REF:P/4/09/ CLP CONSULTATION

ADDRESS : 43 SEA LANE PAGHAM

NATURE OF OPERATION :ERECTION OF REAR DETACHED SWIMMING POOL BUILDING

LOCATION PLAN 1/1250

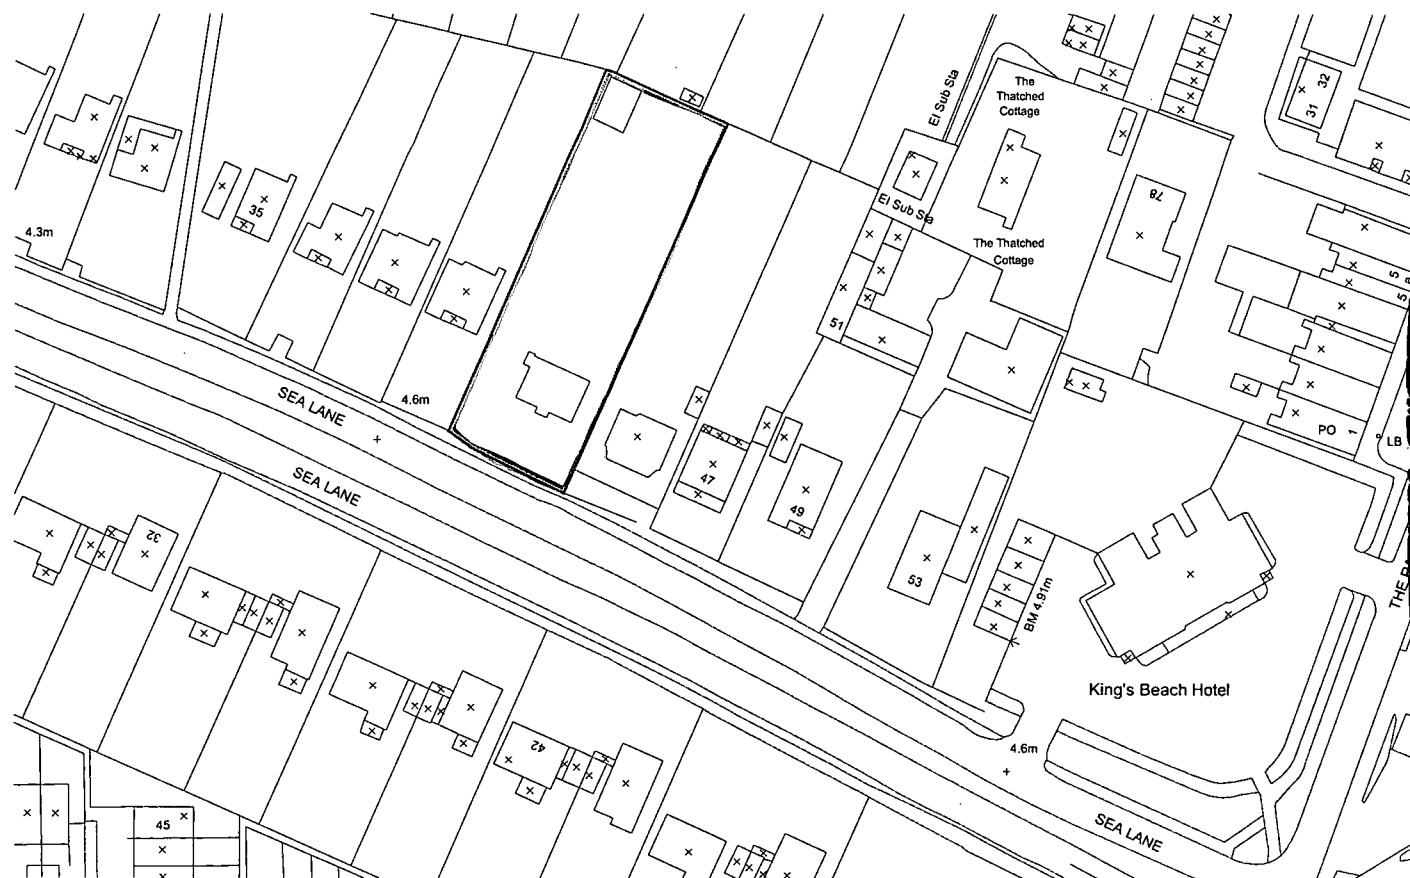
The point now is the size and dimensions. The present application building appears [without making measurements] about the same size and height as the previous application building. Eg see site plans in both cases

Consequently the issue is whether the swimming pool is too large [judged reasonably] for the dwellinghouse it is supposed to be “ incidental to” I think it can arguably be said to be too large as it appears to be as large as the house .

PROPOSED GROUND FLOOR PLAN

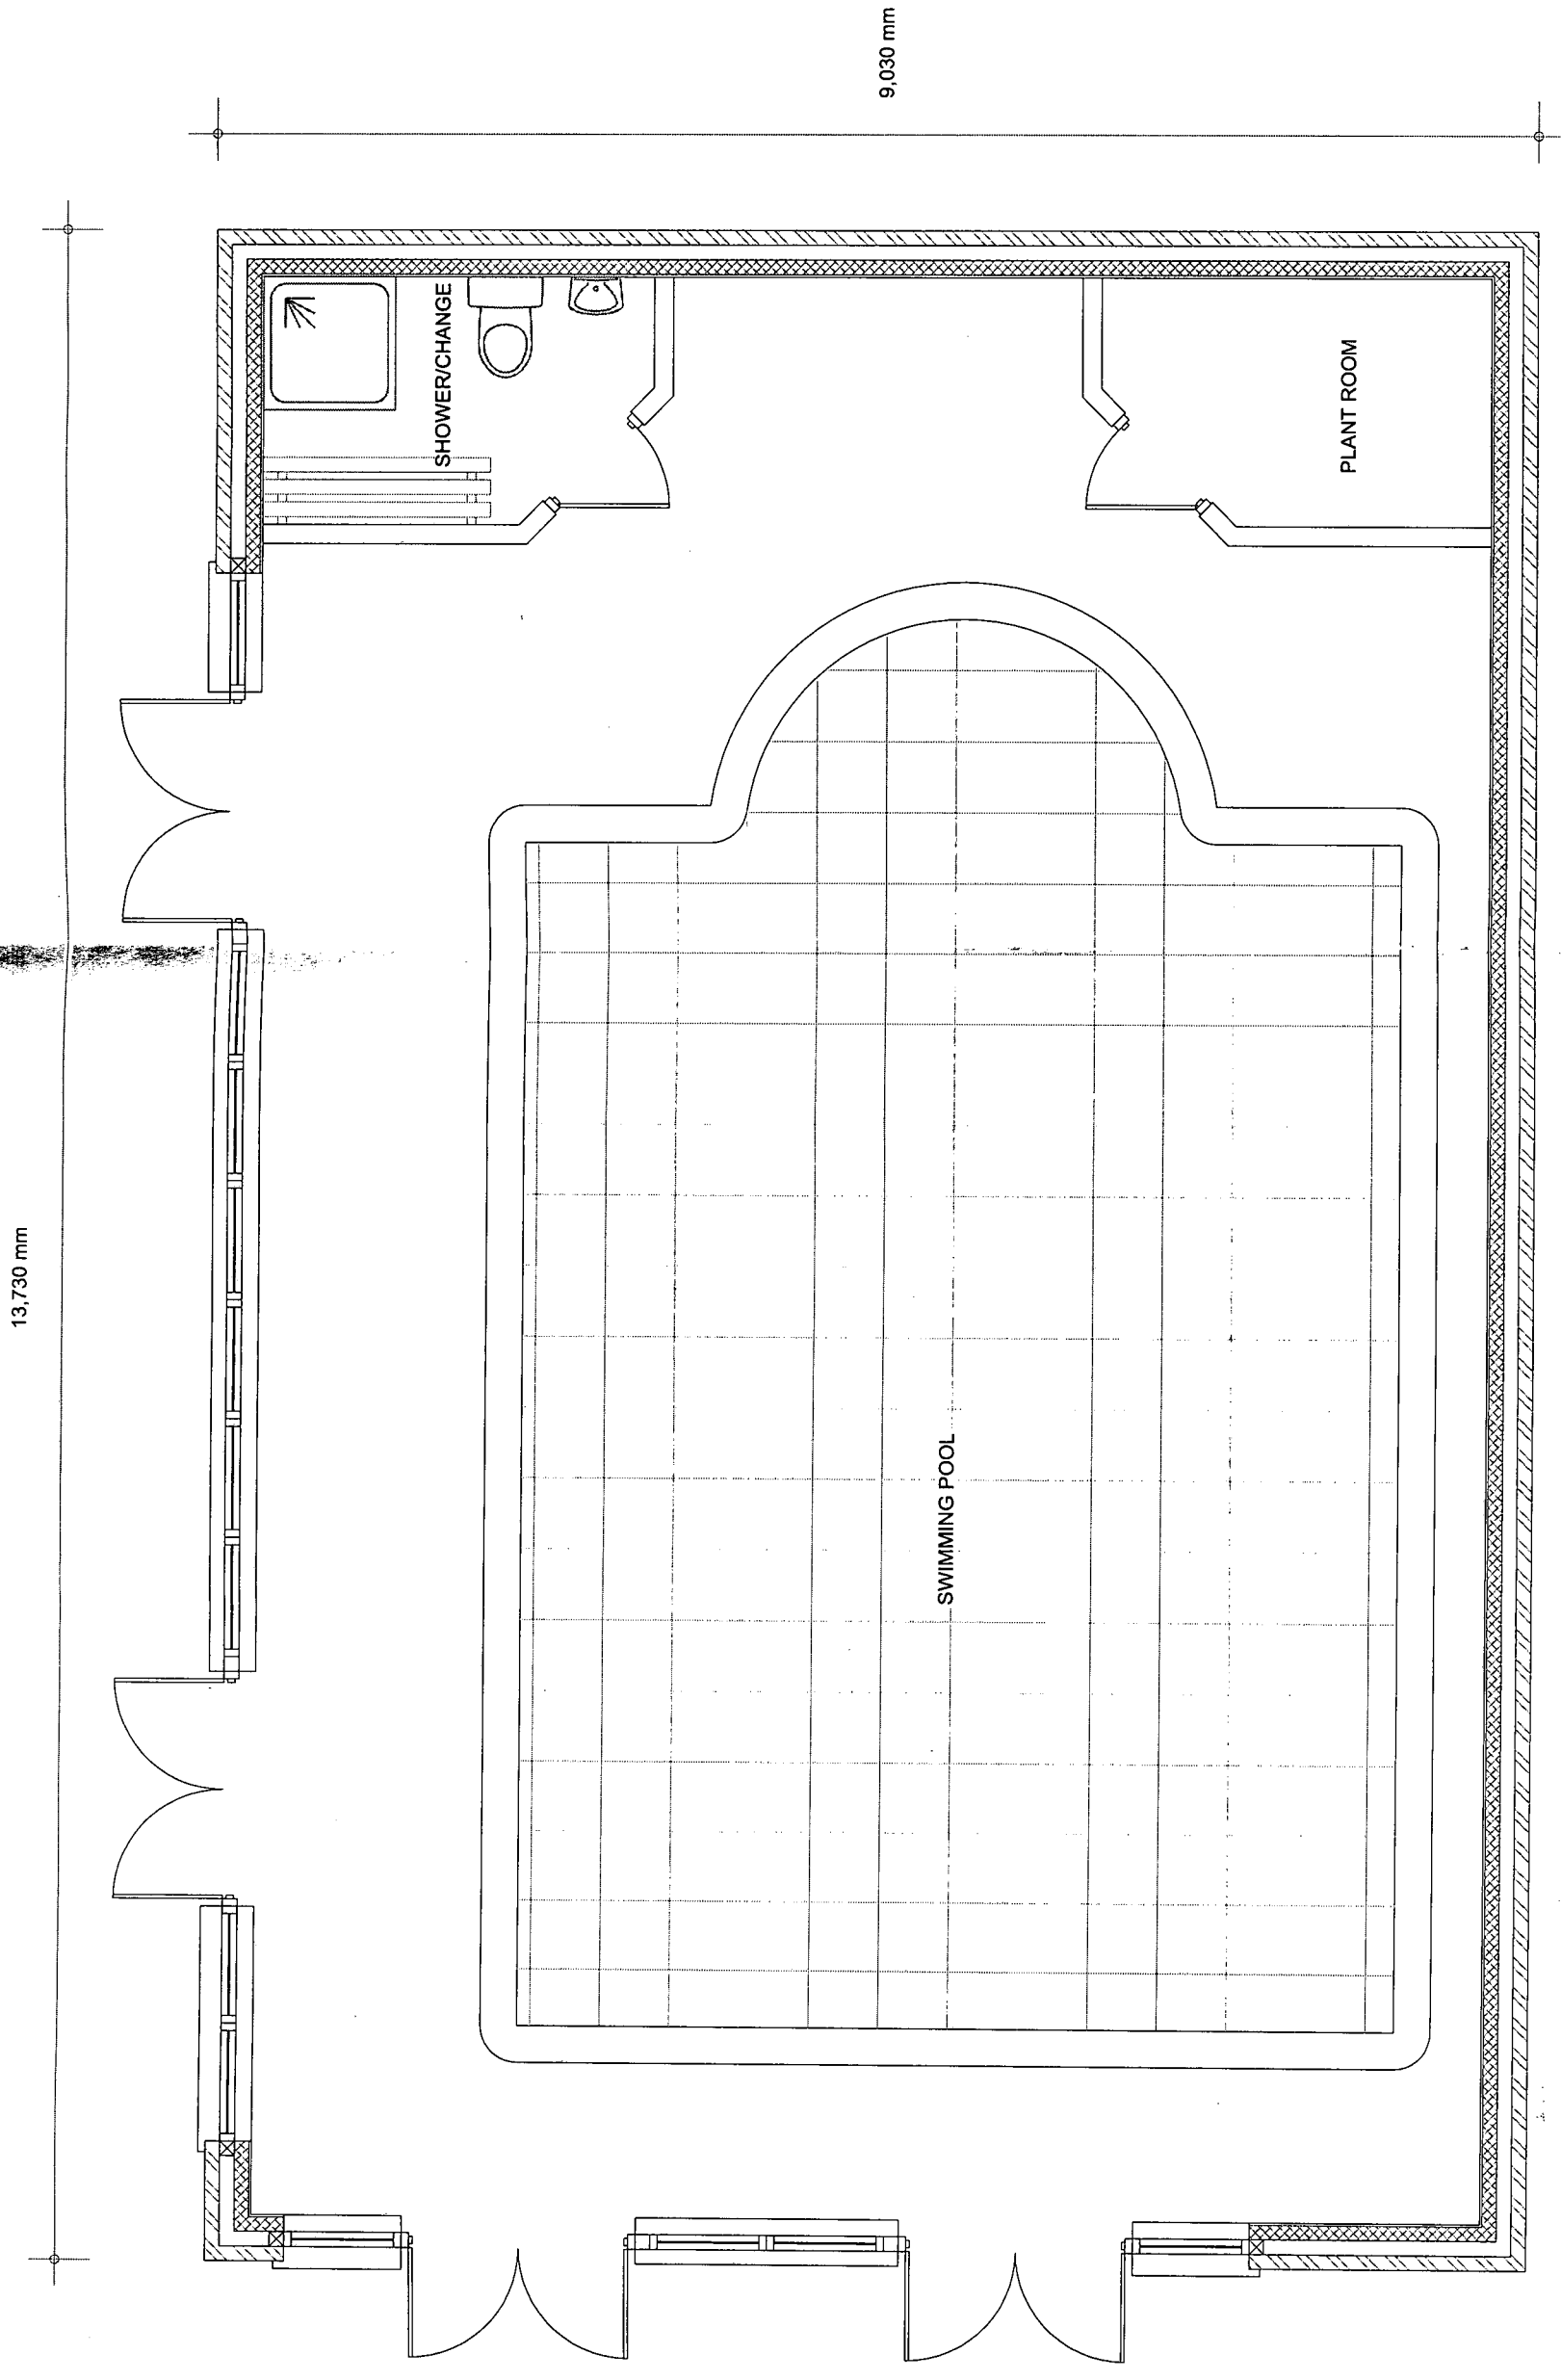
I note that the present application proposes only a swimming pool with plant room [for equipment /workings] and shower room . Previously a combination of leisure rooms was proposed as detailed in full on ref P/76/08/CLE eg gym relaxation snooker study etc .

“incidental “ per eg 1987 JPL 144 means a development of a lesser size and subordinate to the dwellinghouse . The case at 253 Shinfield Road refers to the need for the applicant to evidence the need for a building of a particular size and it is open to you to ask the applicant for evidence to justify such a large swimming pool [which is not seen on file] .
